City of Portland, Maine - Building or Use Permit Application

| Permit No: 02-1181 | Issue Date: OCT 23 2002 | CBL: 02379 F007001 |

| Location of Construction: 41 Christy Rd | Owner Name: Mooradian Judith A & | Owner Address: 41 Christy Rd | Phone: 774-4100** |

Proposed Project Description:
Construct a 16' x 42' Attached Garage w/10' x 16' Deck

DECK SECTION

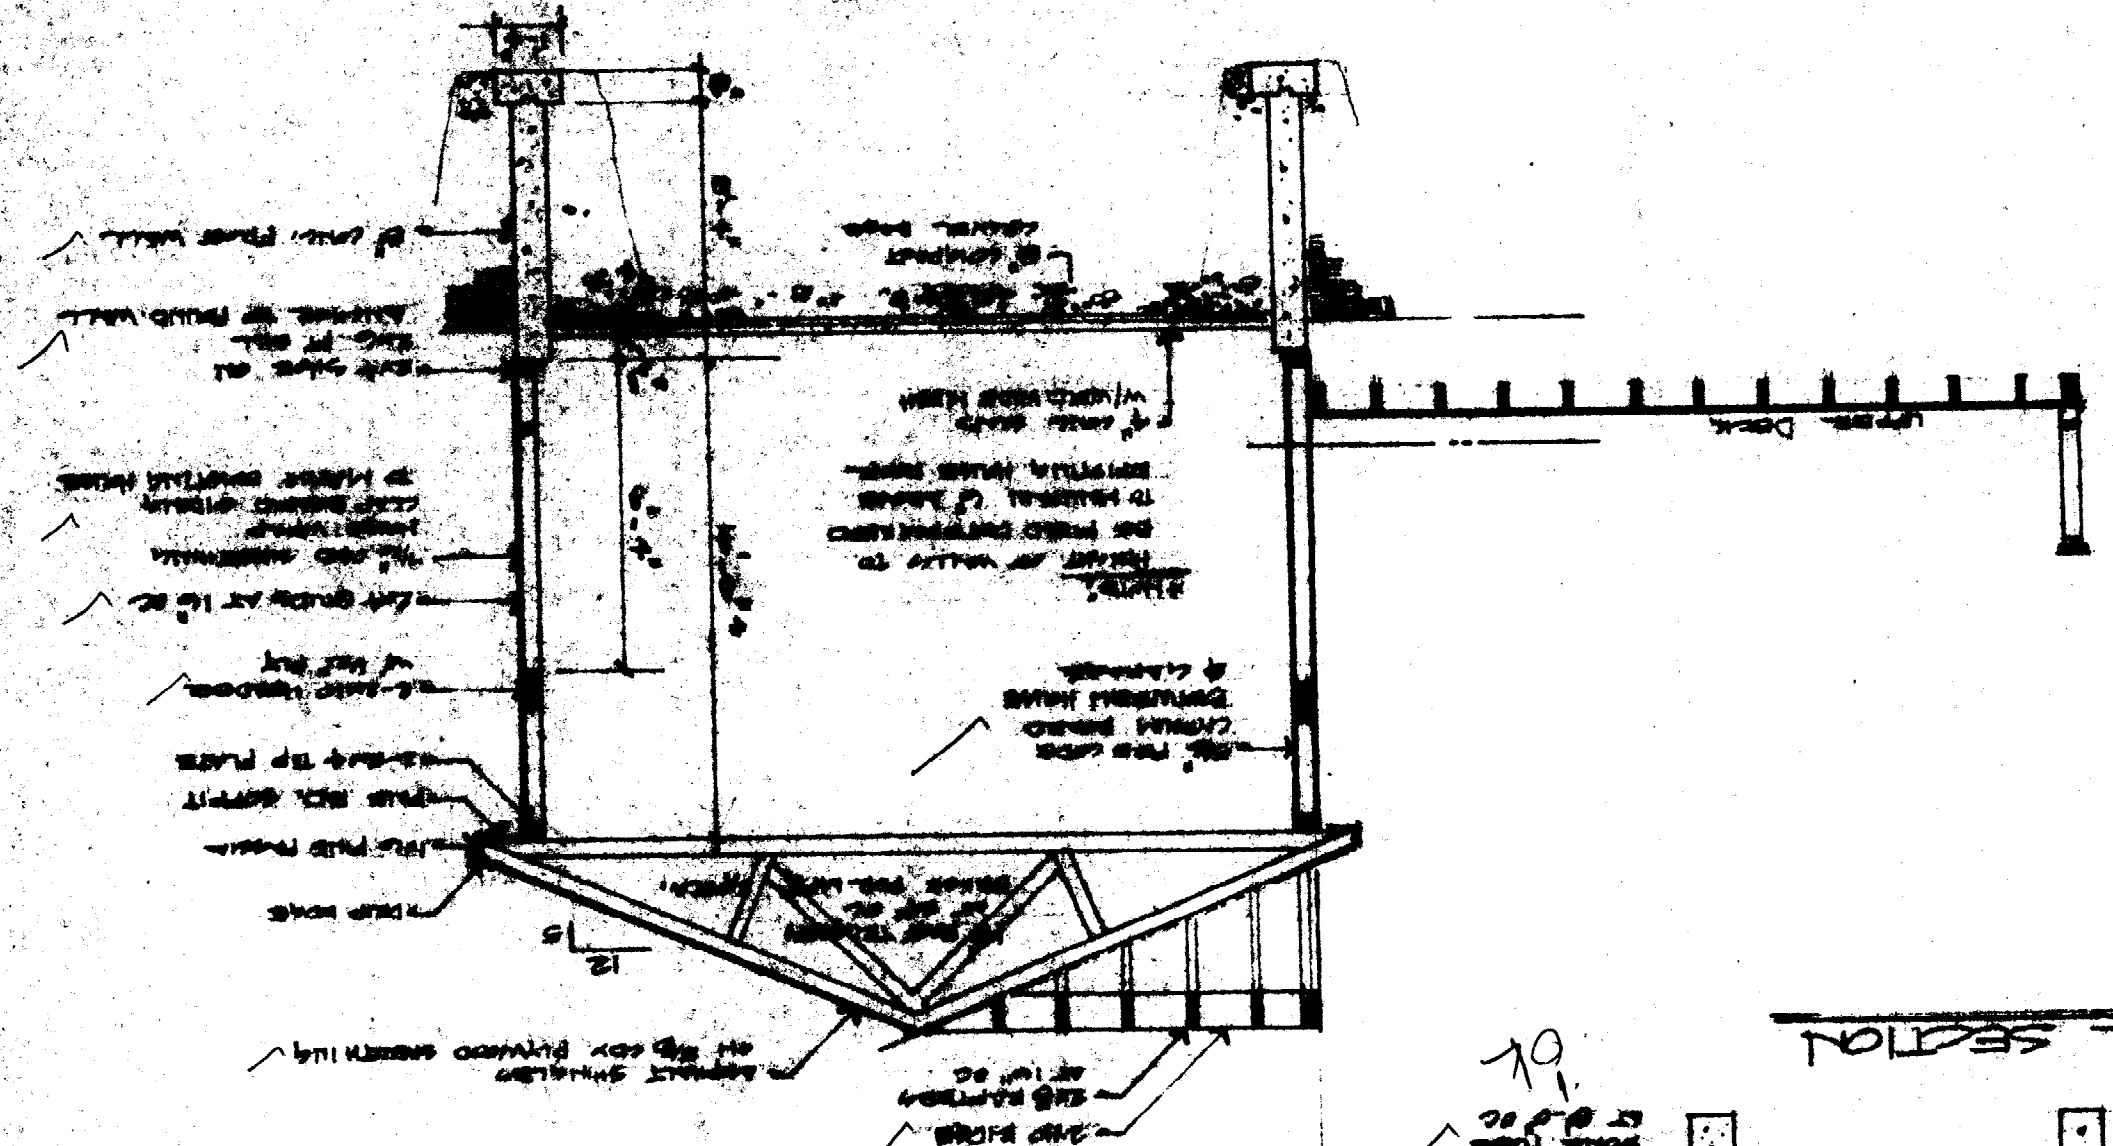
| Add New Condition | Add New Requirement | Delete Condition |
|--|--------------------------|--------------------------|
| Guardrails and handrails(w/returned ends) are required when there is a difference of grade 15-1/2" or more on open sided walkways or platforms, or when there are more than 2 risers. Max. Baluster space is 4". | | |

Plot Plan

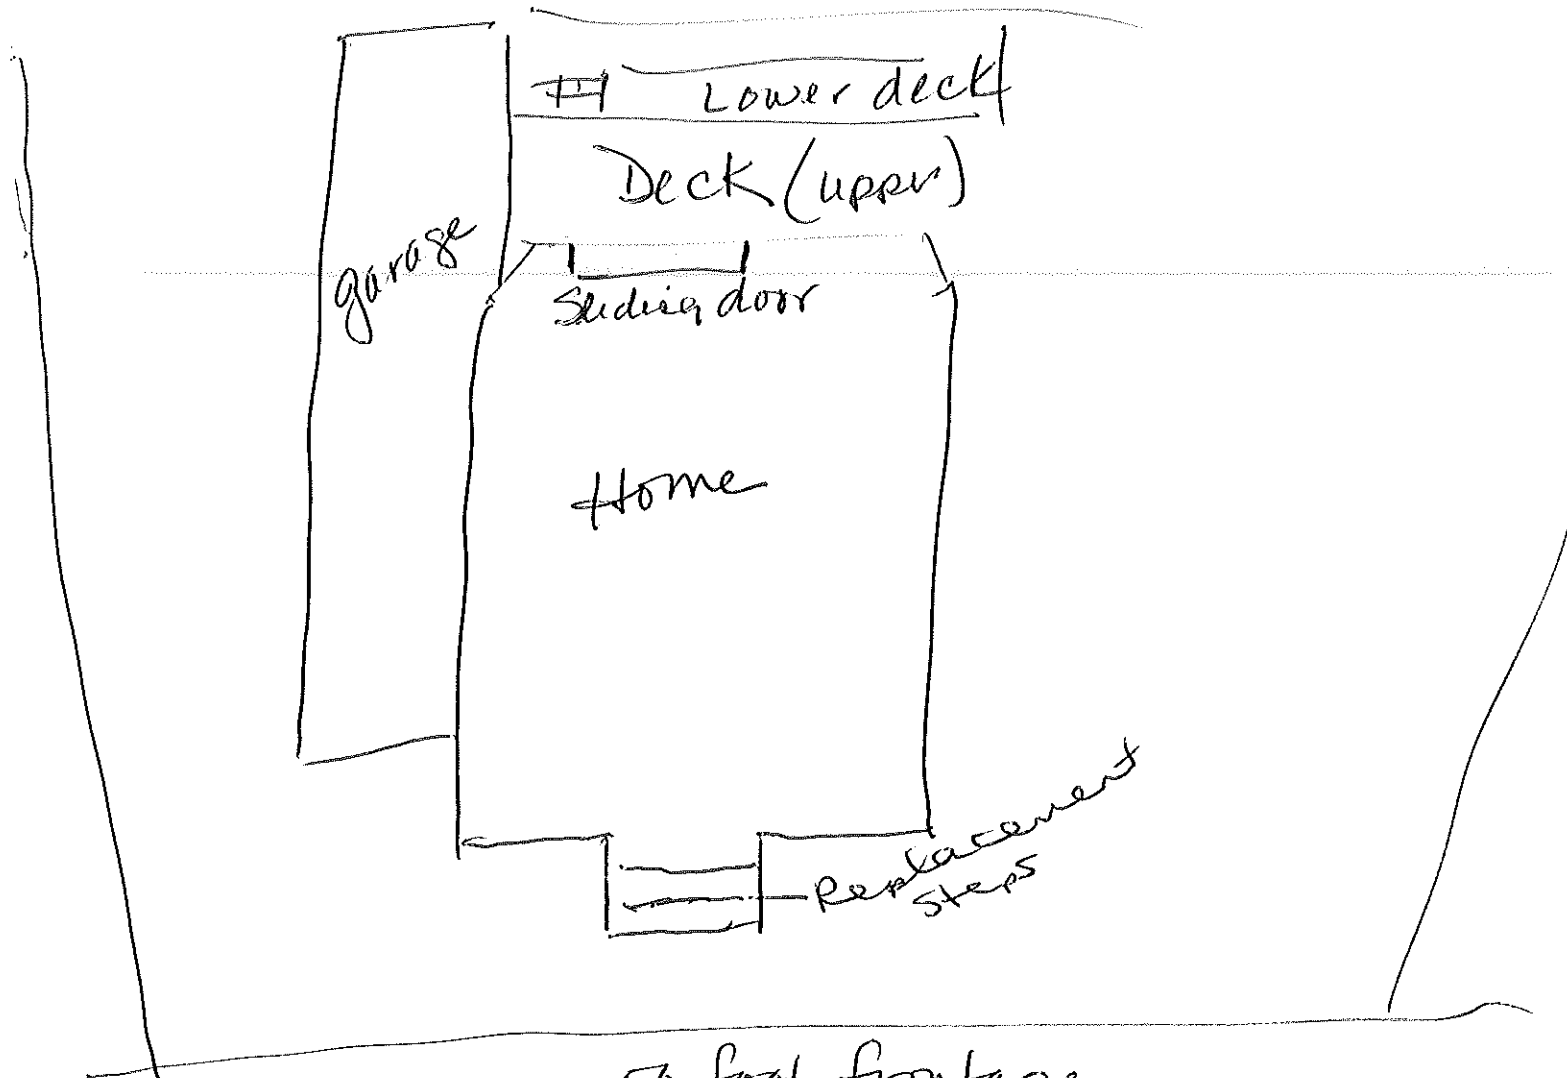
Sec. 14-433 allows a setback reduction for accessory structures were the principal structure existed as of July 19, 1988 in the R2 Zone. Rear - 10' & Side - 5'.
